Subject: EES comments on amended Environmental Impact Statement and Response for Submissions for Lane Cove West Data Centre – SSD-9741 – 1 Sirius Road Lane Cove West

Subject: EES comments on amended Environmental Impact Statement and Response to Submissions - Lane Cove West Data Centre – SSD-9741 – 1 Sirius Road Lane Cove West

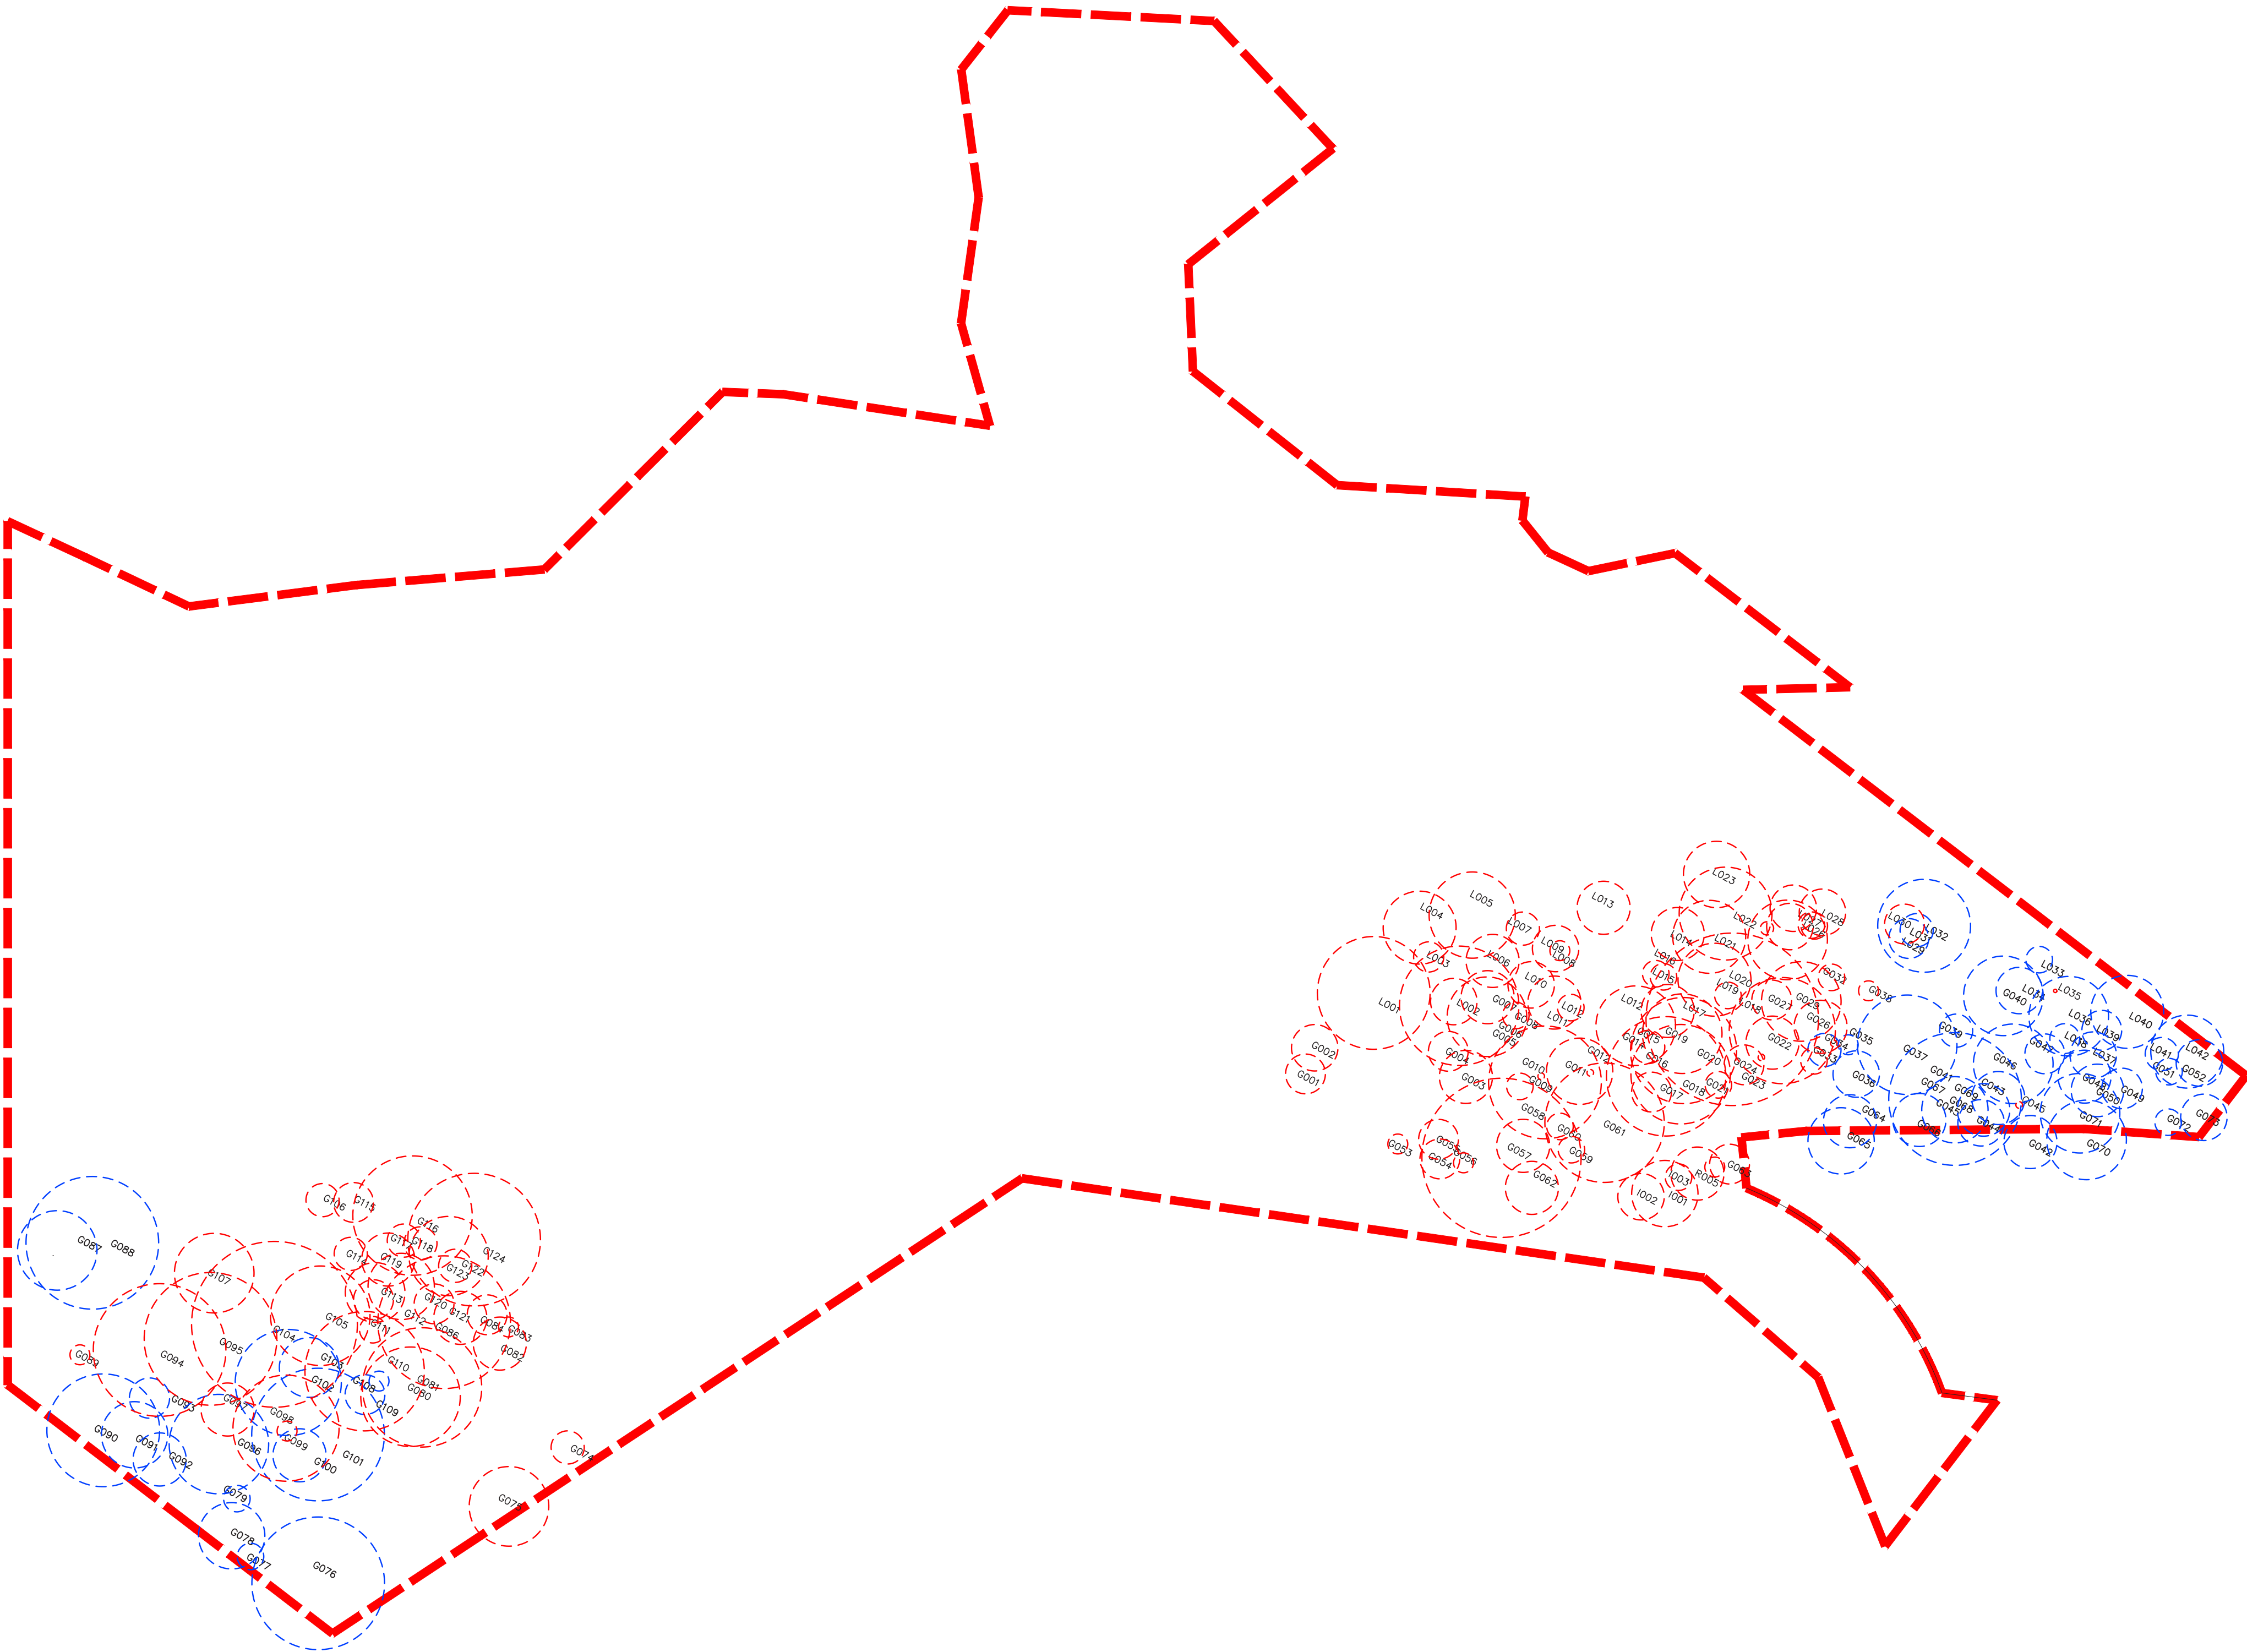
EES notes Drawing No. LDA-05 in the landscape documentation proposes to retain a number of invasive exotic trees at the site including:

- 6 x Camphor Laurel (*Cinnamomum camphora*)
- 3 x Large-leaved Privet (*Ligustrum lucidum*)
- 1 x Small-leaved Privet (*Ligustrum sinense*) and
- 1 x Black Locust *Gleditsia triacanthos*.

It is unclear why Drawing No. LDA-05 proposes to retain these invasive trees. EES notes that none of these exotic species are hollow-bearing trees comprise so it appears they are not being retained to provide native fauna tree hollow habitat (see page 24-25 of VMP). The proposed retention of these invasive trees is not consistent with the VMP which notes invasive species such as Camphor Laurel, Large-leaved Privet and Small-leaved Privet require intensive weed control and ongoing eradication (see section 3.2, page 13 of VMP) and it lists these species as target weed species with very high priority (see Appendix 2).

The spread of seed from these invasive trees from the site is a concern as the Lane Cove National Park is located to the west of the site.

The removal of these additional 11 trees from the site will add to the total number of trees being removed and EES recommends:

- the Department clarifies with the proponent if the proposed retention of these invasive exotic trees in Drawing No. LDA-05 is a typing error.
- the landscape documentation is amended to remove (and not retain) these invasive tree species from the site
- the invasive exotic trees are replaced with local native provenance tree species.
